Located At 56 HAMMOND ST

Job ID: 2012-06-4359-CH OF USE

has permission to Demo existing structure, build new 3 story, 3 unit apt., 1 of 2 on Parcel B, single exit enclosure provided that the person or persons, firm or corporation accepting this permit shall comply with all of the provisions of the Statues of Maine and of the Ordinances of the City of Portland regulating the construction, maintenance and use of the buildings and structures, and of the application on file in the department.

**Jeanie Bourke - RE: 56 Hammond St BP#2012-06-4358 & 4359 plan review comments**

**A001**  
 PERMIT SET  
 5/18/2012

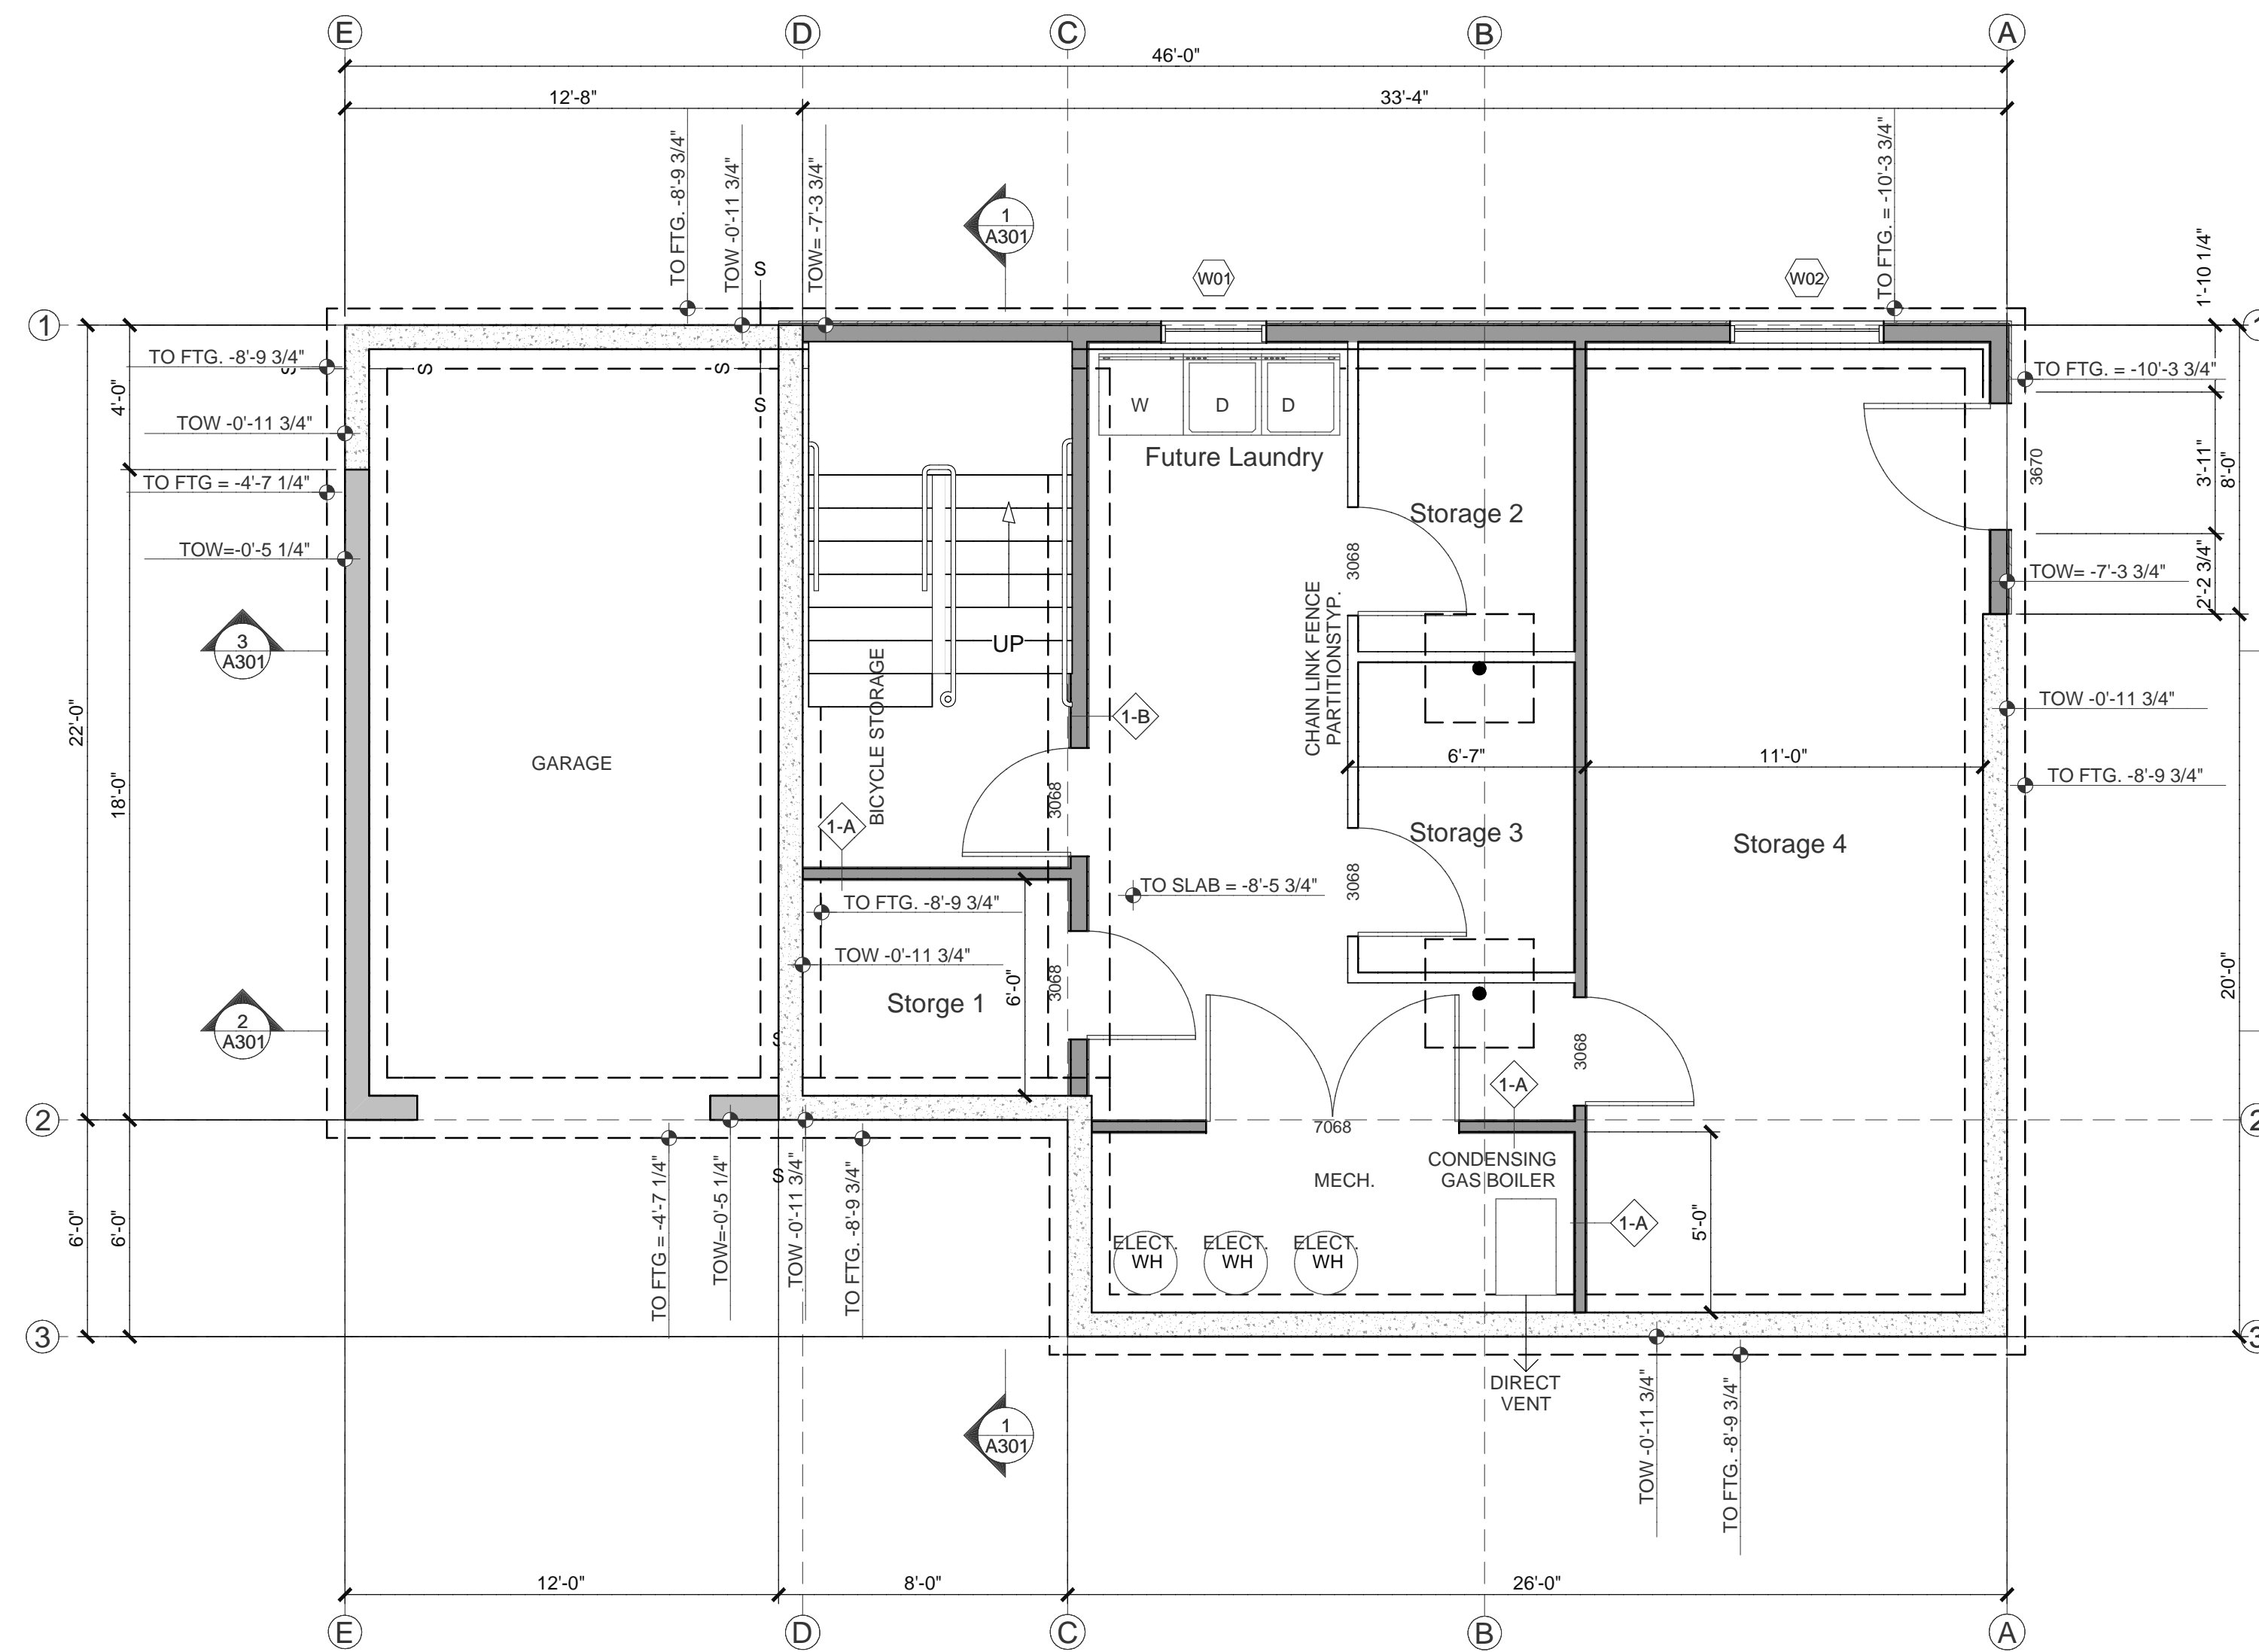
· Provide justification for the .5 hour ceiling type (2 clg) on Plan A000 per IBC Sec. 712.3  
*Section 709.3 exception 2 allows a rating of 1/2 hour in buildings of type VB construction equipped with an automatic sprinkler system. This assembly rendered moot by your question regarding sound transmission below. See attached SK-2 drawing defining new assembly.*

· Clarify the W/C type reference on Plan A000 for IBC 26-1.1 and 14-1.14, as they relate to UL assemblies

· Provide W/C assembly compliance for sound transmission per IBC Sec. 1207

*This reference is to the wall assembly "Item Number" described in IBC Table 720.1(2) "Rates Fire Resistance Periods for Various Walls and Partitions"*

*See attached SK-2 drawing defining new assemblies to address this section.*
